Application by Highways England for the A303 Sparkford to Ilchester Dualling project

The Examining Authority's written questions and requests for information (ExQ3)

Issued on 25 April 2019

FIGURE 2.5  
HAZLEGROVE JUNCTION UNDERBRIDGE  
GENERAL ARRANGEMENT

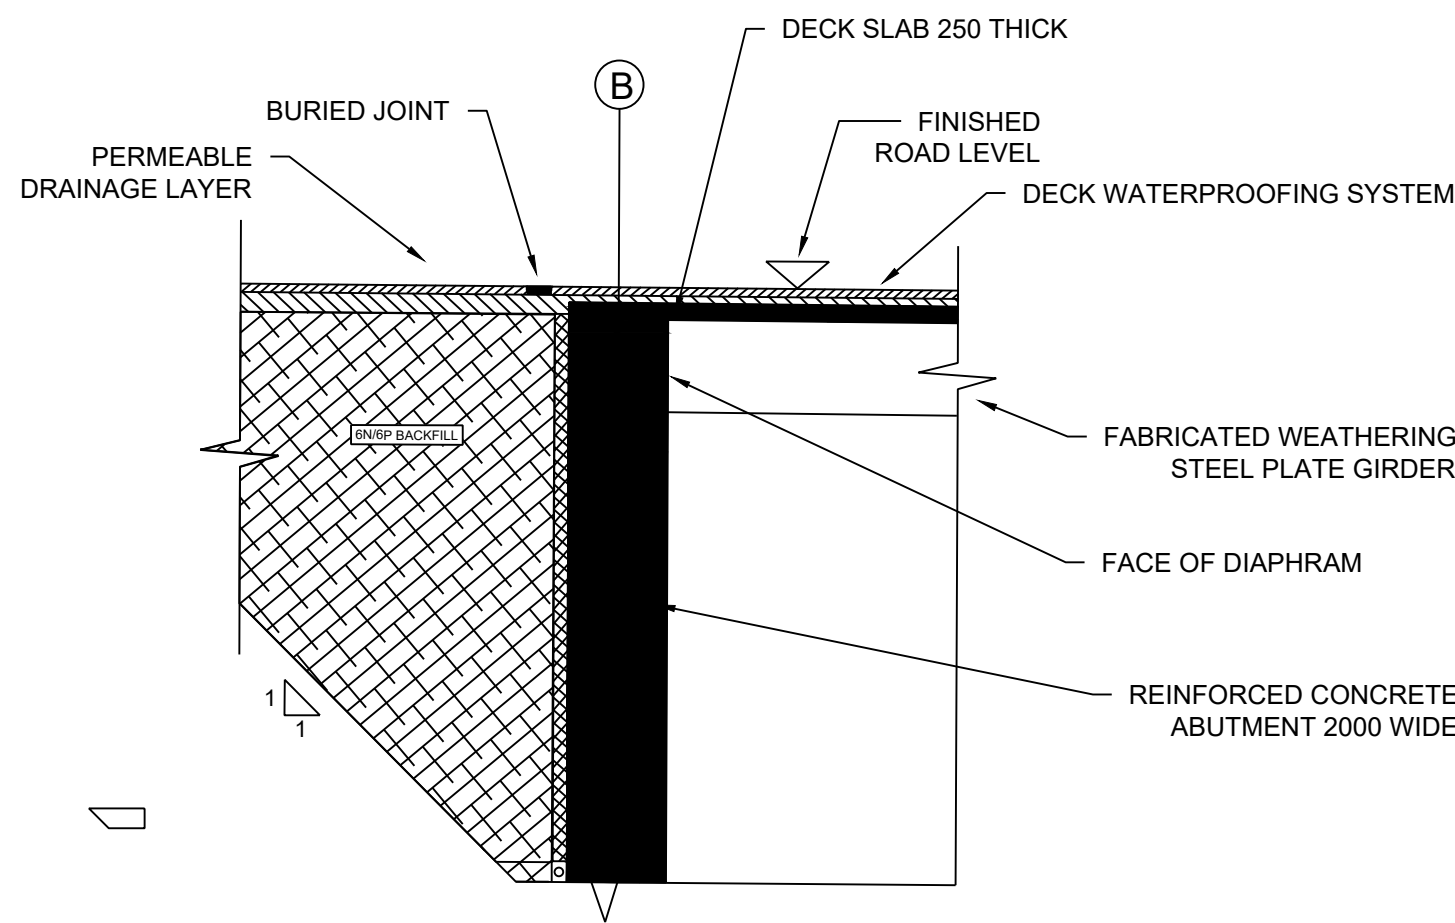
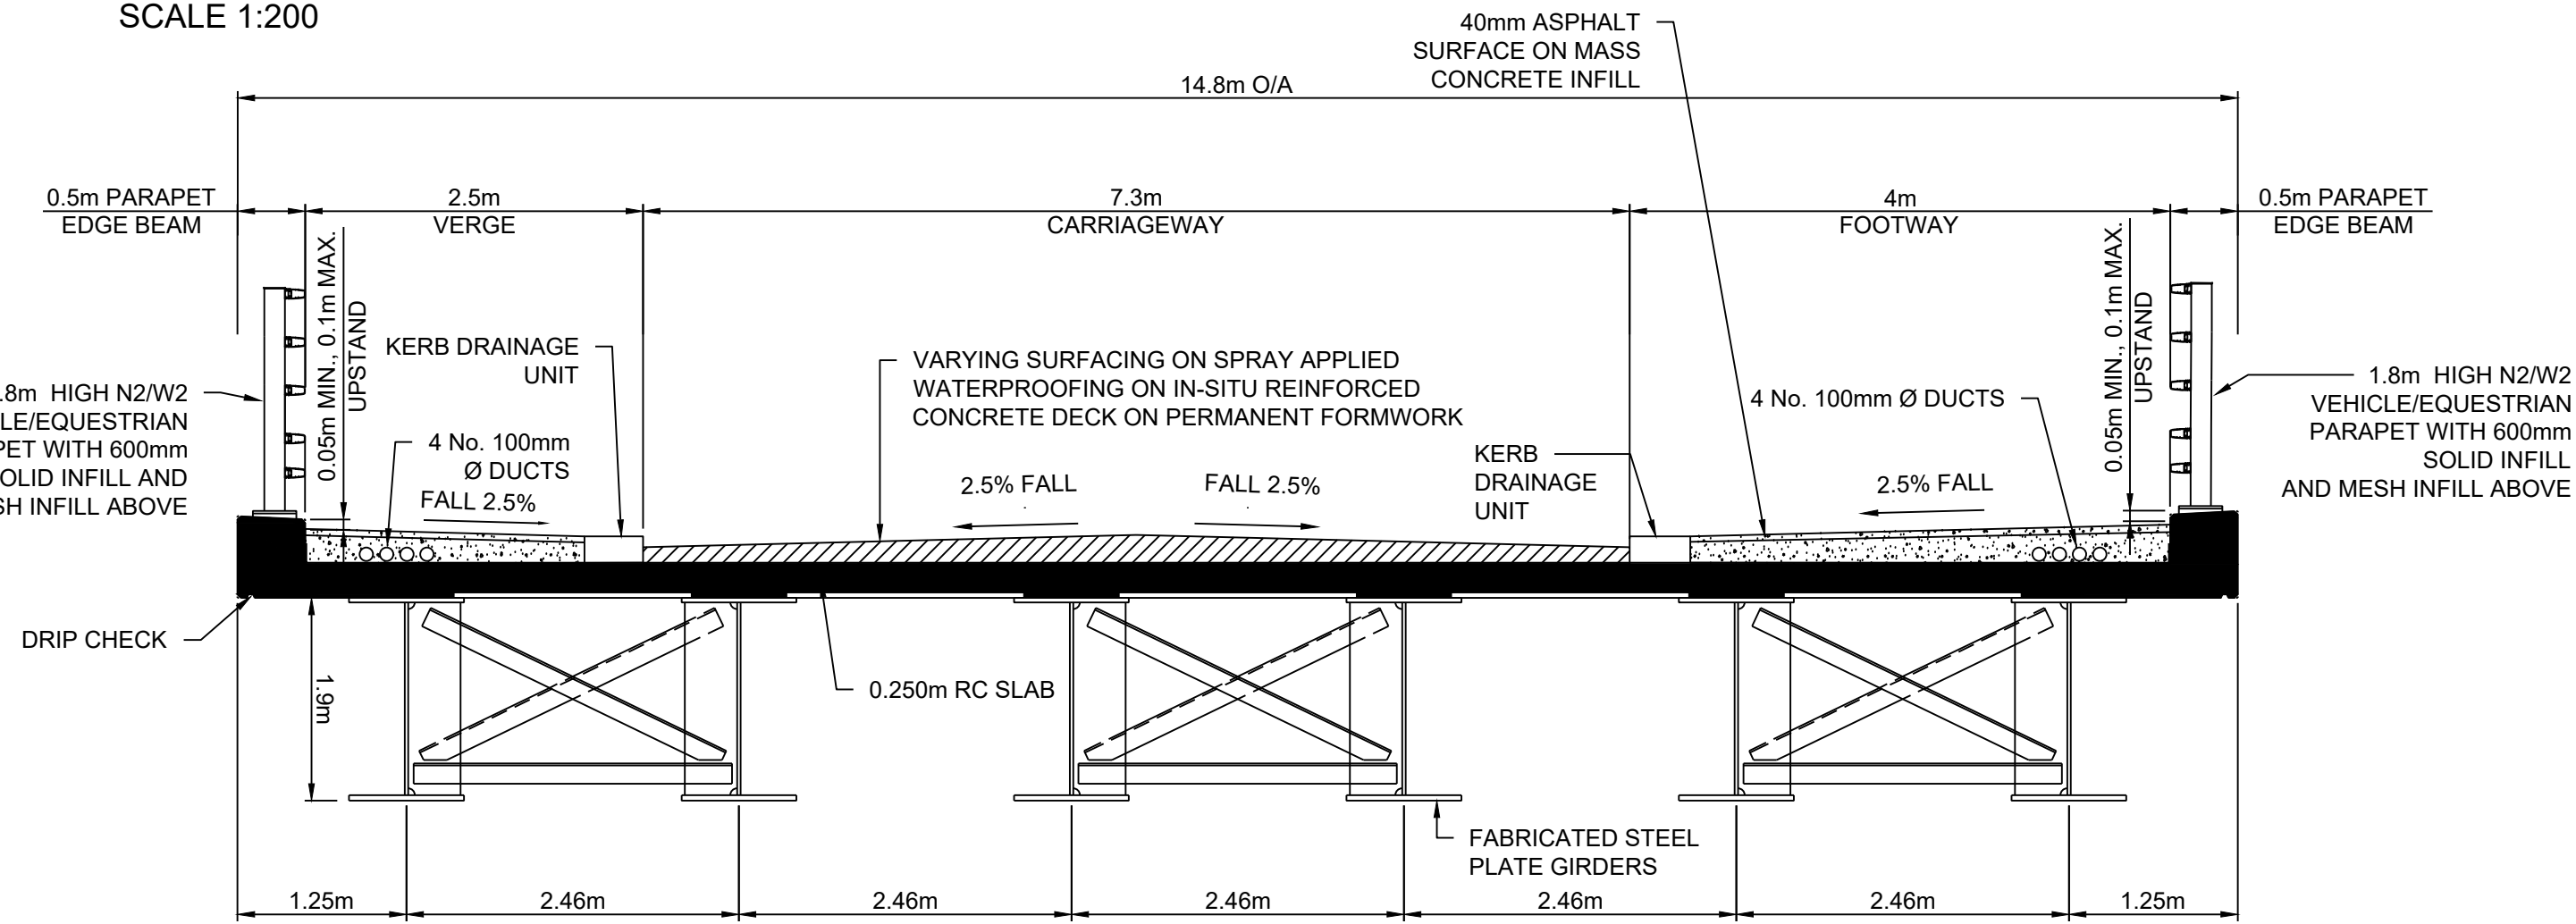
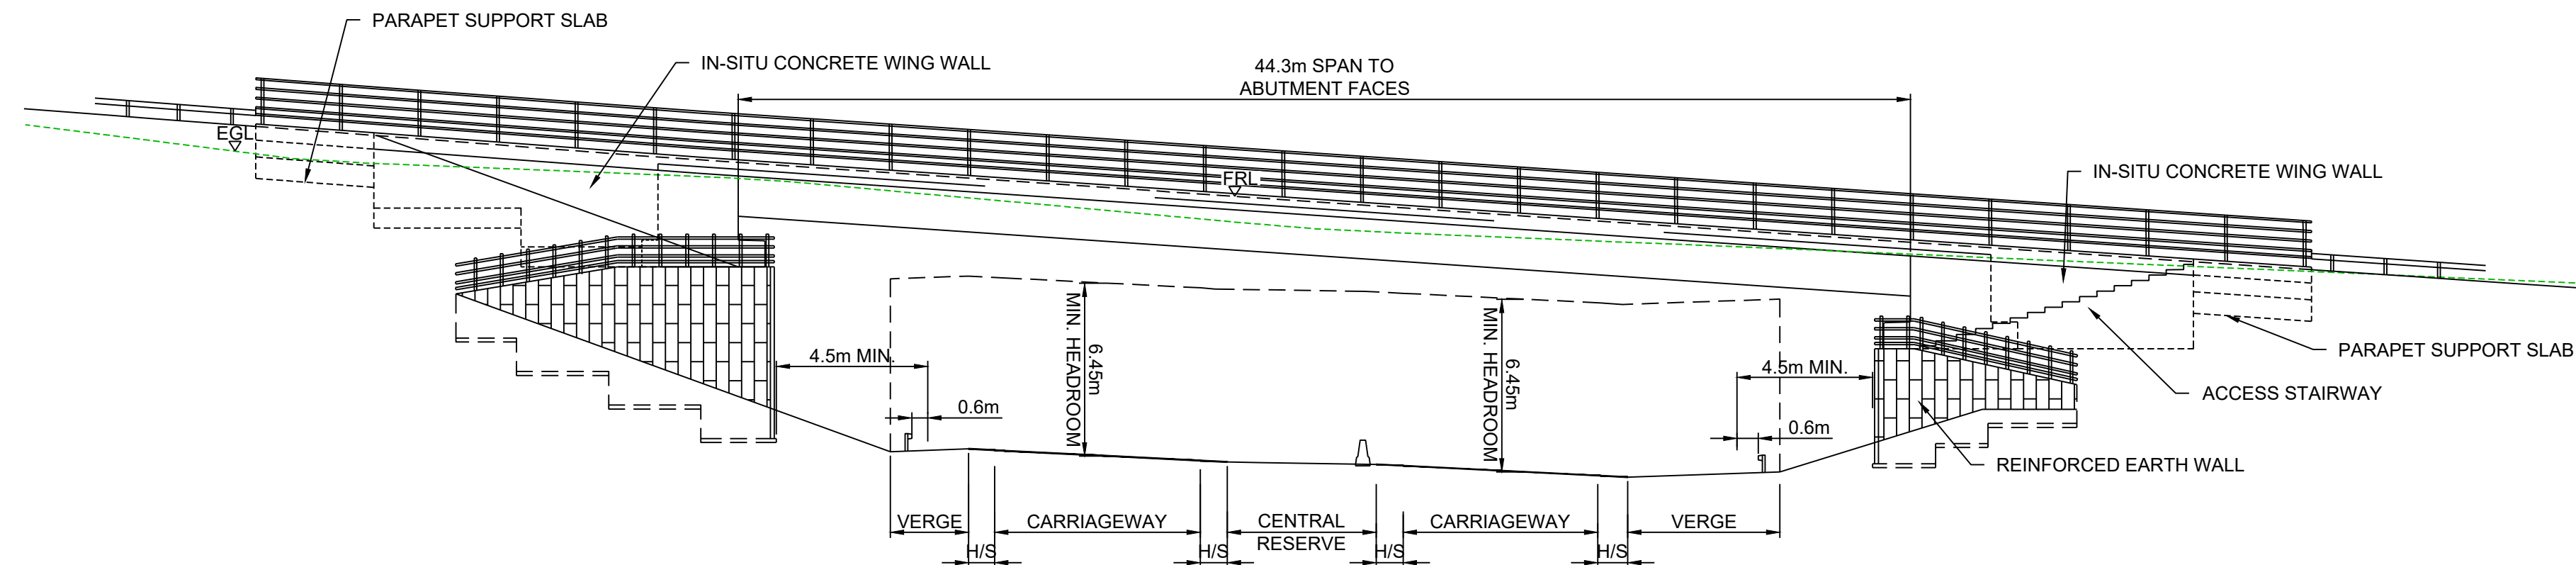
3.6.7	The Applicant	<p>Underbridge The Applicant's responses to the ExA's Further Written Questions 2.6.6 and 2.6.8 [PD-014] acknowledges that due to its enclosed nature the underbridge may introduce a brief reduction in comfort and attractiveness and that this will need to be addressed by way of detailed design.</p> <p>Can the Applicant provide an indication as to how the design could address this matter?</p>

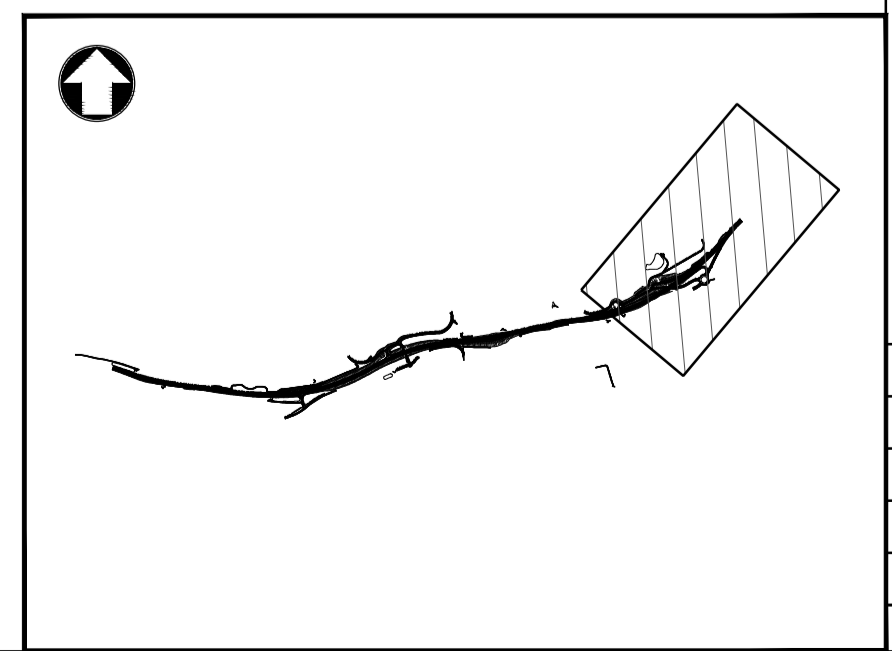
3.0.12	The Applicant SCC SSDC	<p>Scheme Lighting Within the draft Statement of Common Ground between the Applicant, SCC and SSDC [REP5-017], SCC comments on the responsibility of the proposed lighting system. The Applicant states that this is a matter of detailed design.</p> <p>It is unclear why this should be a matter of detailed design. What mechanism is in place to address this detail?</p>

Figure 2.2 Main site compound.

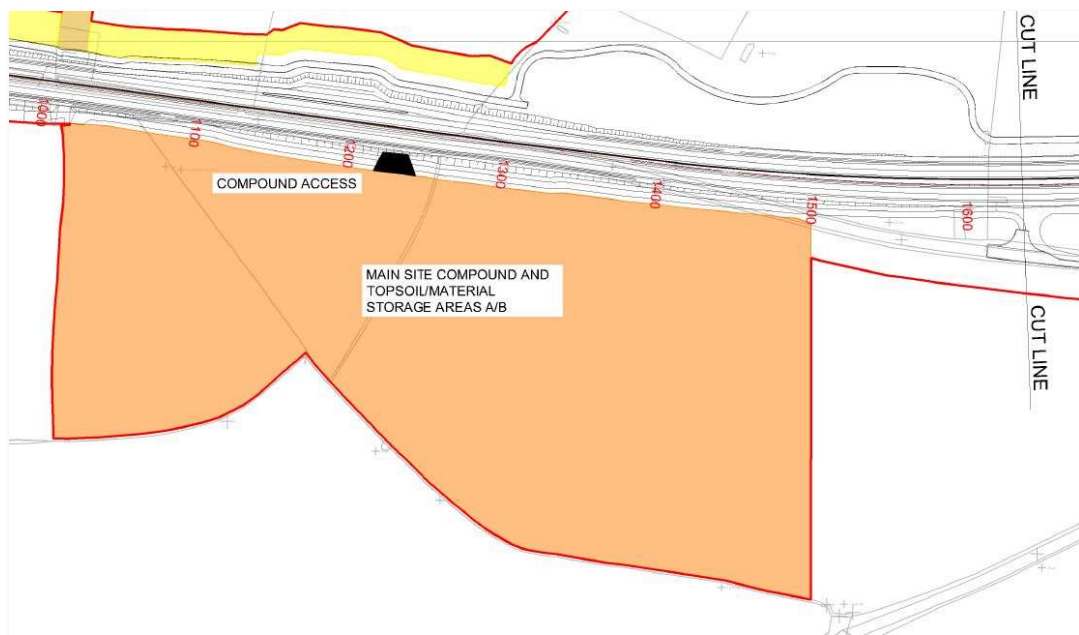
3.5	Landscape and Visual Effects	
3.5.1	The Applicant	<p>Artificial Lighting</p> <p>a) The accepted change [PD-012] includes a new location for the main site compound. Could the Applicant please explain on the basis the site specific location the effects of artificial lighting during the construction period in terms of its landscape and visual effects?</p> <p>b) Once these assessments have been undertaken could they please be included within the cumulative assessment of the proposal?</p>
